Subject: FW: app3/2013/0488 Higher Jud Falls Stonyhurst

From: Bloomer, David [mailto:David.Bloomer@lancashire.gov.uk]
Sent: 21 June 2013 13:32
To: Colin Sharpe
Cc: ENV LHS Customer Service
Subject: app3/2013/0488 Higher Jud Falls Stonyhurst

Block Plan

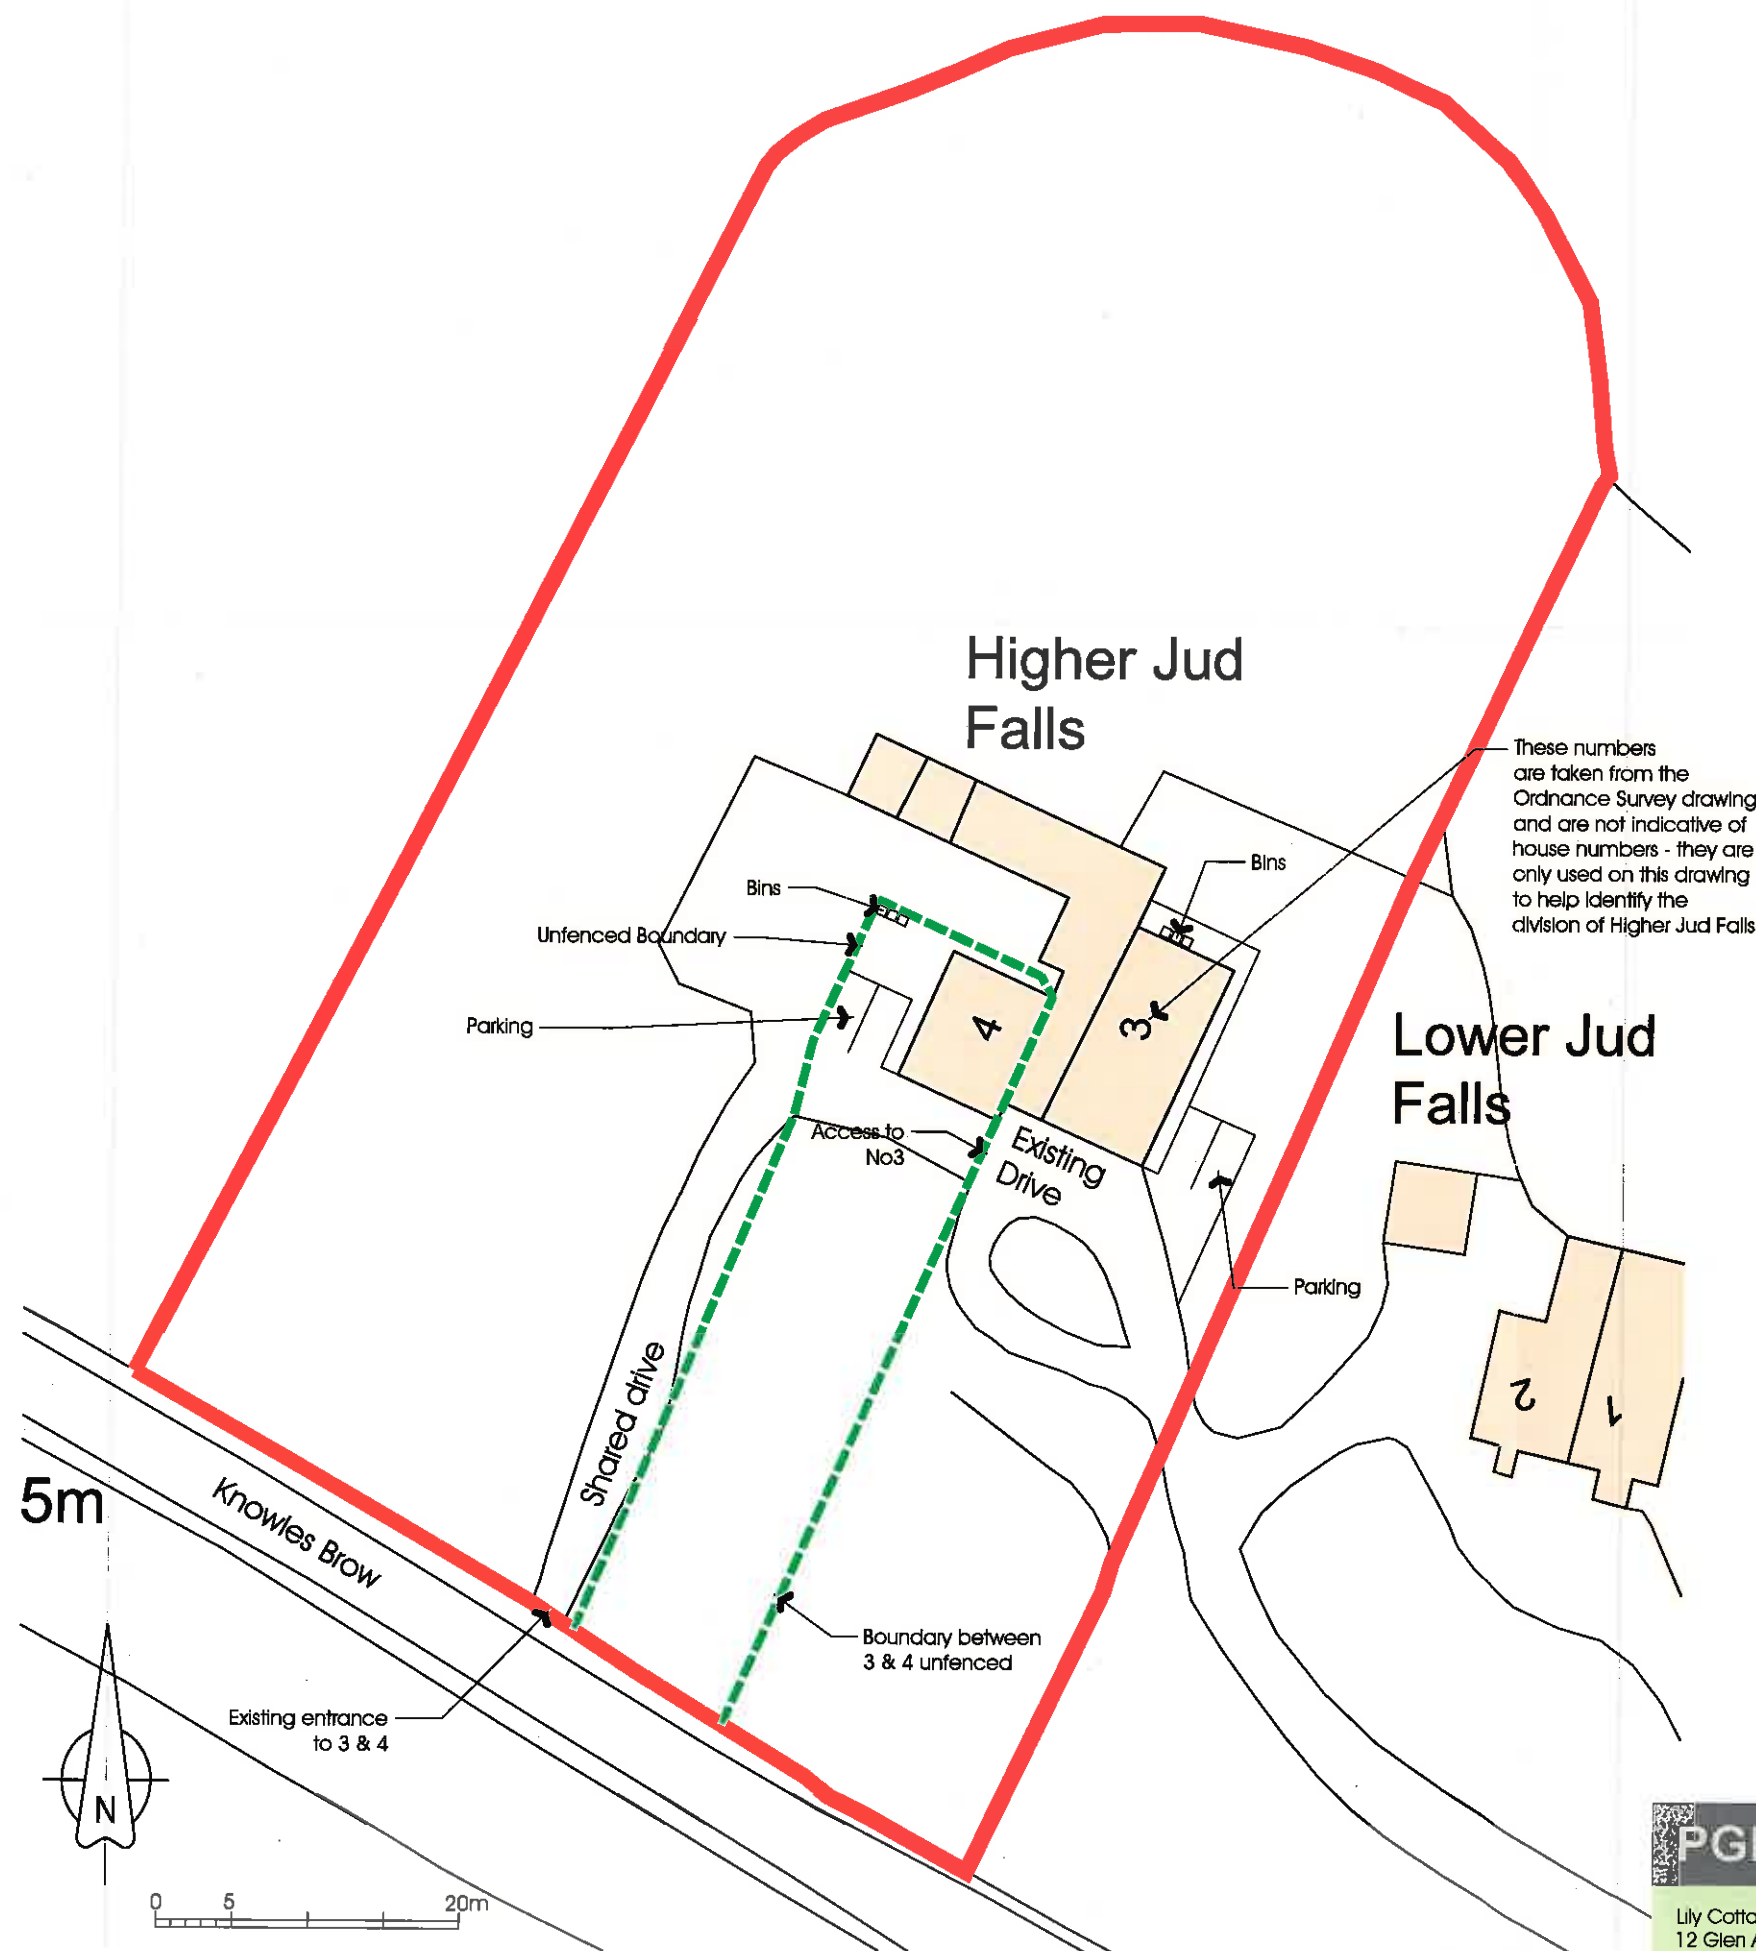
I would raise no objection to the principle of the proposal but would request a clarification of the access arrangements to the properties which are the subject of this application. Will both (3 and 4) properties be served from the westerly access or can the easterly access (past 1 & 2) be used?

For the avoidance of doubt the submitted scheme shall include details of the proposed width (5m minimum), surfacing and visibility splays/vegetation removal
